May 12, 2014

I am the owner/Landlord of No3 Angmering Villas, as well as being the Builder/Developer who originally built the properties and would just like to make a couple of points about Mrs Edwards retrospective planning Application.

DRAWING TITLE
NEW FRONT BOUNDARY WALL
ELEVATIONS, PLAN AND SECTION

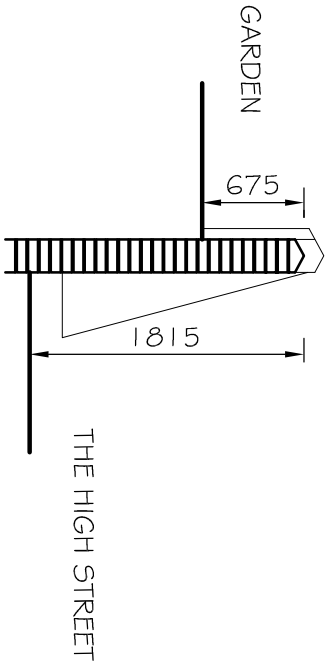
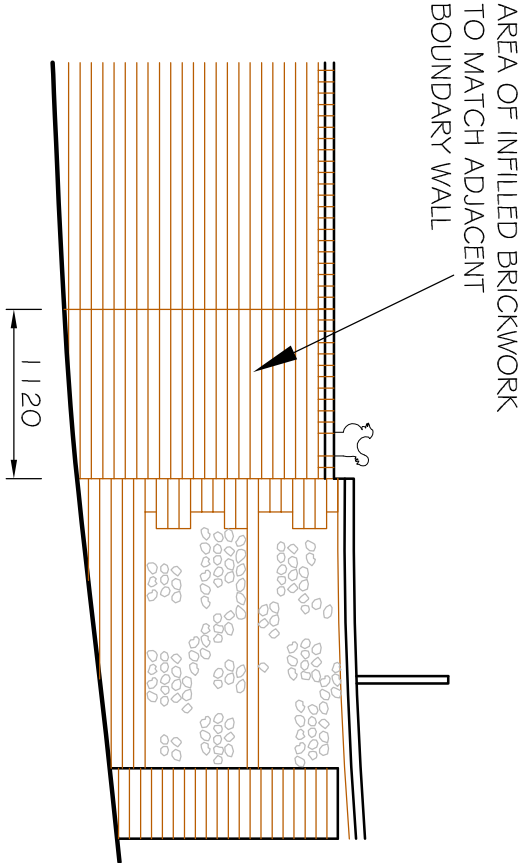
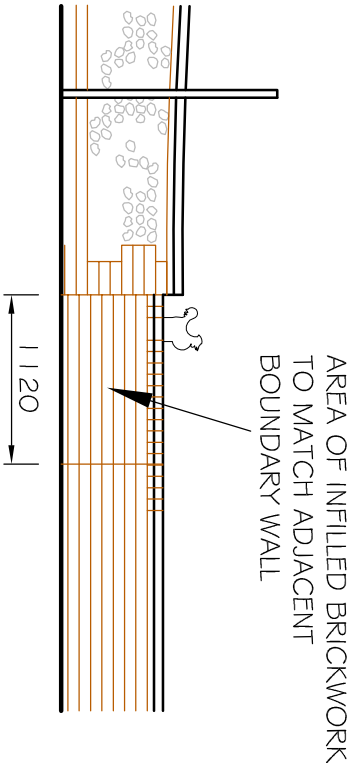
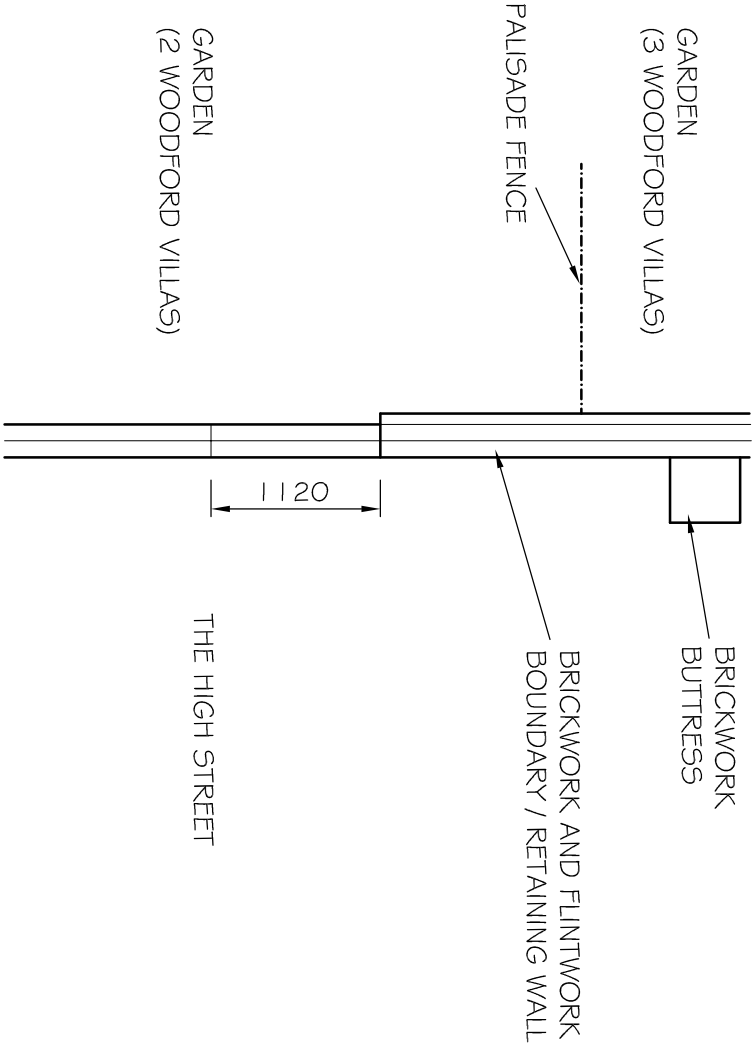
Notwithstanding the poor standard of building work carried out without any structural calculations or consideration for the conservation area, when we unfortunately had the flint wall collapse on us while building Angmering Villas we had to go through a lot of Planning consultations to ensure that the new wall was in complete keeping with the area and that flint was the only solution that was acceptable.

I can accept that there is not a lot that we can do, no matter how much it has upset everyone in the area, about the infilling of the wall itself, I am however concerned that it should at least be built properly and in keeping (without a Chicken on top) and urge you not to allow the fence in front of the property that leaves us with an entrance that looks like we have to go through someone's front garden to access our Homes. We Have Open Access rights to our properties, and while there isn't a gate put up, I feel the fence, especially at that Height, has just been put there to make a point and not for any other reason.
